MEMORANDUM

To: FILE
From: Jean Fraser
Subject: Application ID: 2013-187
Date: 9/5/2013

Comments Submitted by: Marge Schmuckal/Zoning on 8/30/2013

This project is to demolish an existing (abandoned) two family dwelling and to replace it with a 6 residential condominium. The project is in the R-6 zone and uses the regular R-6 zone dimensional requirements. However, because the existing building is on the existing rear property line, the rebuild is able to be moved forward and use section 14-433 to allow building additions to be within 5' of the side and rear line for buildings existing as of July 19, 1988. The existing building was present well before that date. The required front setback is being met.

1
A-202
NORTH ELEVATION
SCALE: 1/4"=1'-0"

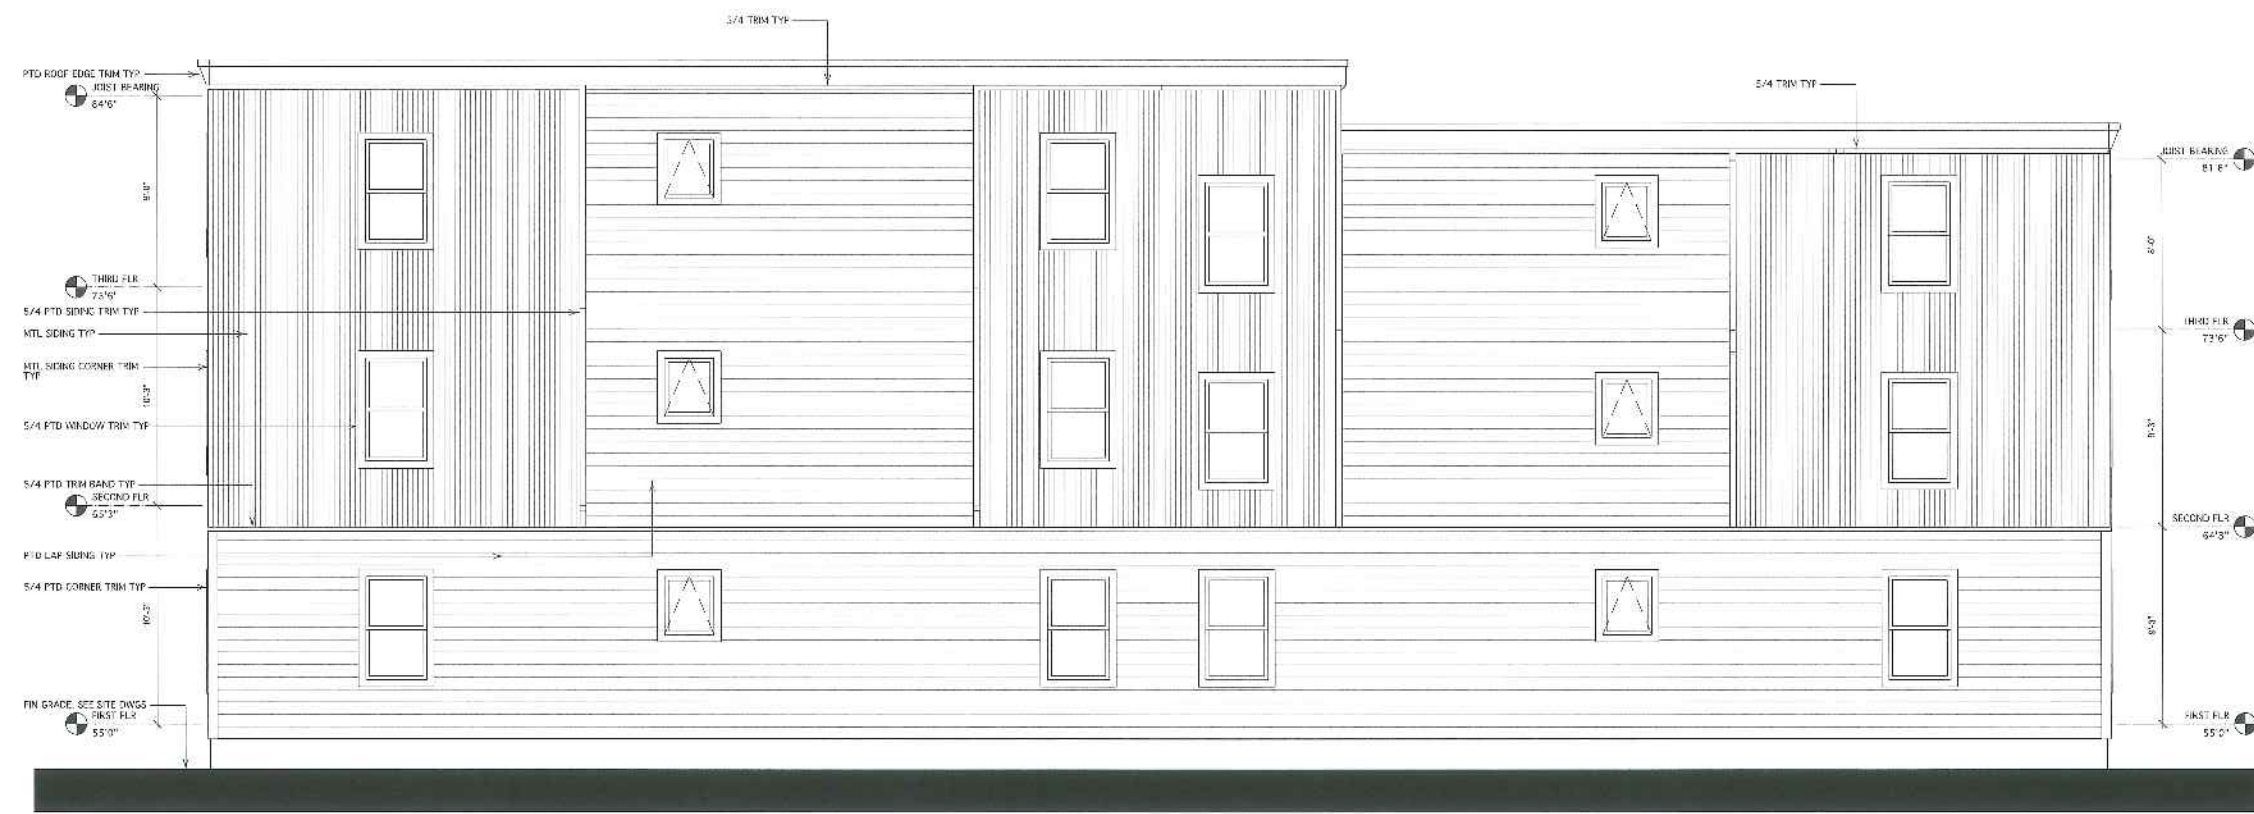
The building height is being met (under 45'). However, the dimensions are being shown to the joist bering and not to the top of the joist as required by definition. I would like to see revised drawing that show the building height from grade (or average grade) to the top of the roof beam.
